6 ASSESSMENT

6.1 Director General's Report

6.1.1 The purpose of this submission is for the Director General to provide a report on the project to the Minister for the purposes of deciding whether or not to grant approval to the project pursuant to Section 75J of the EP&A Act.

Figure 1 Site Plan Showing Exhibited and Amended Proposals (Source: HASSELL Pty Ltd)

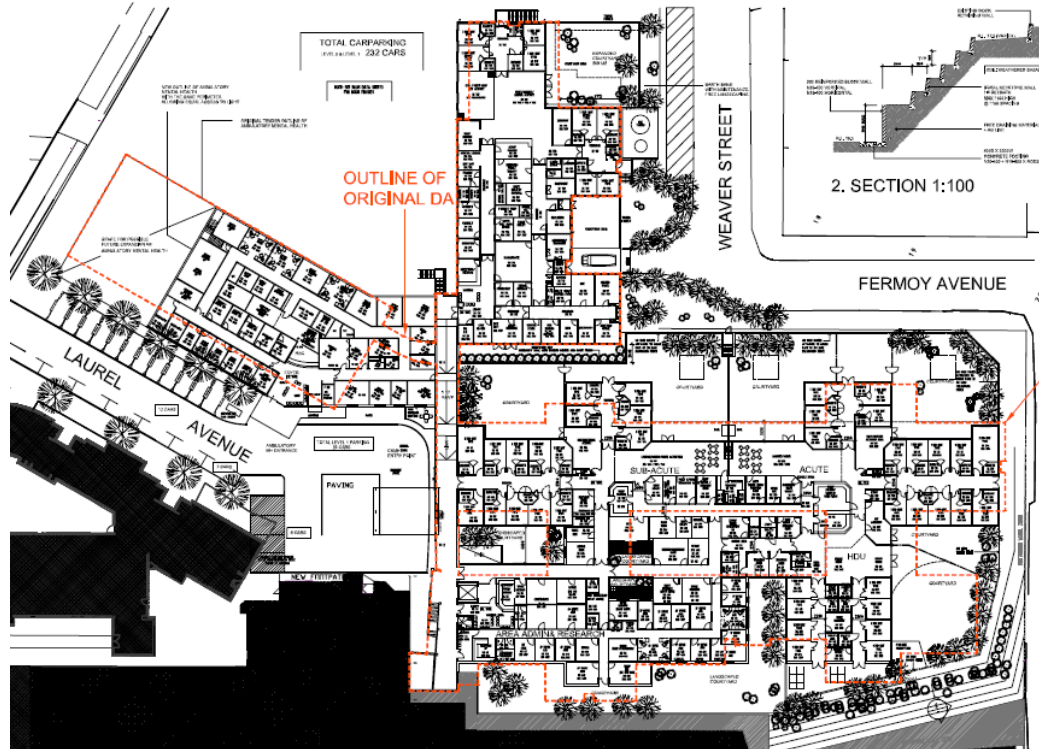
- 6.5.5 An opportunity has been taken to redesign and reconfigure some of the buildings to address local resident's concerns relating to loss of amenity and perceived security and safety issues. This has resulted in reducing the visual impact of the buildings and improved their functionality within the site as well as some internal courtyard areas being expanded for the benefit of both patients and staff.

- 6.5.7 The redesign and relocation of the ambulatory care unit approximately seven metres to the east of the Hunter Street boundary will reduce its visual impact. Similarly, the height of the child and adolescent unit has been reduced by one metre and realigned parallel to the other buildings so as to create a more logical extension of built form.

Figure 3 South and North Elevations: Sub-Acute, Acute, High Dependency Unit and Administration (Amended Proposal) (Source: HASSELL Pty Ltd)

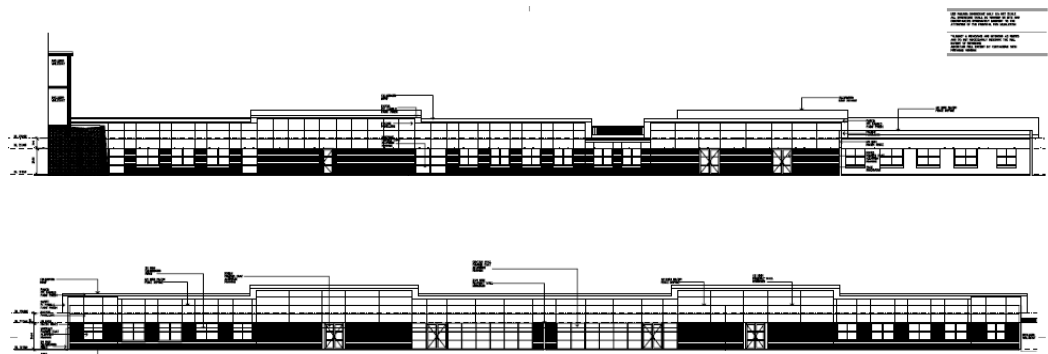
- 6.5.8 Other amendments have been made such as decreased roof heights which has been achieved by changing the original skillion roofs to gabled roofs and the deletion of three roof level plant rooms and platforms (to now be located at ground level). The internal configuration has been amended so as to better cater for the needs of future users of the facility.

Figure 4 General Arrangement Car Parking (Amended Proposal) (Source: HASSELL Pty Ltd)

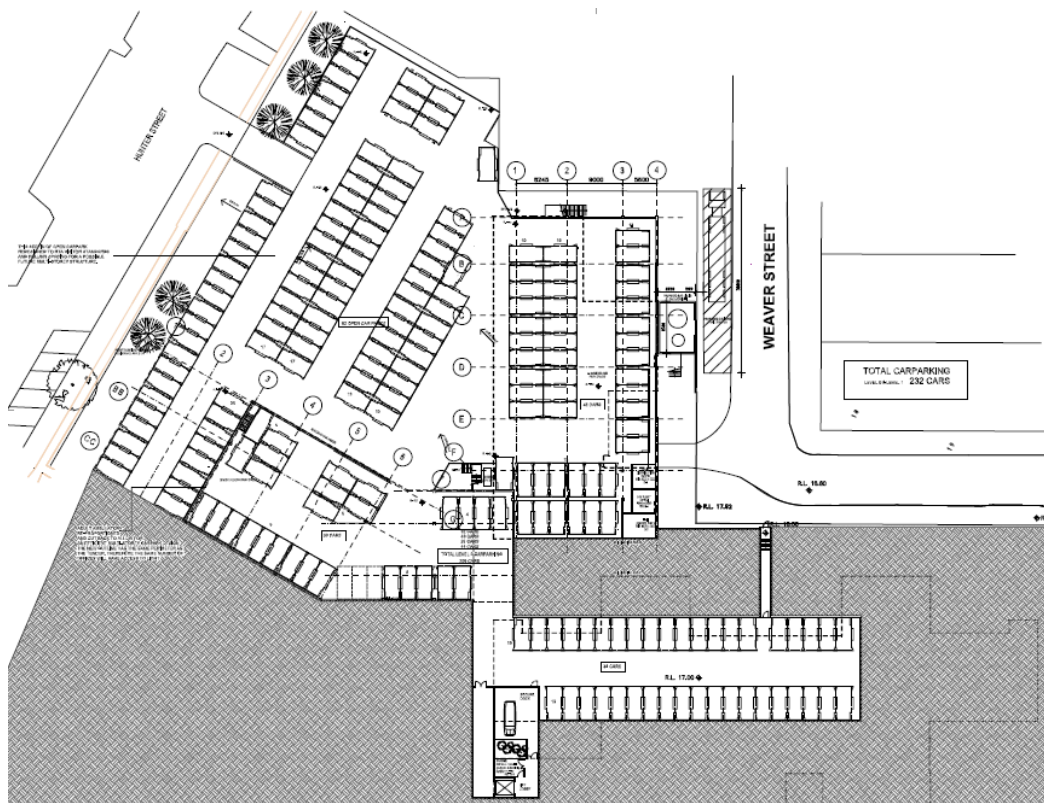
- 6.4.6 However, in response to the issues raised in submissions, the proponent amended the nature and extent of overall car parking provision on the site. Whilst the revised proposal includes the removal of the upper level of the proposed two storey car parking facility, car parking capacity has increased to 416 car parking spaces primarily through the establishment of basement car parking under the adult inpatient unit (see Paragraph 3.6.16). Other increases have been made on ground level, the undercroft area beneath the ambulatory care unit and the main entry road and set down area.

- 6.4.8 The amended proposal involves a reduction in the amount of on-street car parking in favour of an increased proportion of off-street car parking. The proportion of on-street car parking has been agreed with Council and will be upgraded with kerb and guttering at cost to the proponent for use as informal hospital car parking. The proponent has reconfigured the car parking provision as part of its preferred project submission to better reflect the needs of patients, visitors and staff thereby further exceeding Council's car parking requirements by 12 spaces.

- 6.4.11 It is recommended that an additional condition be imposed requiring the provision of 416 car parking spaces with a bitumen sealed/paved or equivalent surface constructed in accordance with relevant Council requirements. Furthermore, additional signage should be erected to clearly indicate that off street car parking is available and provision of disabled car parking is provided in accordance with relevant Australian Standards (Condition B7).
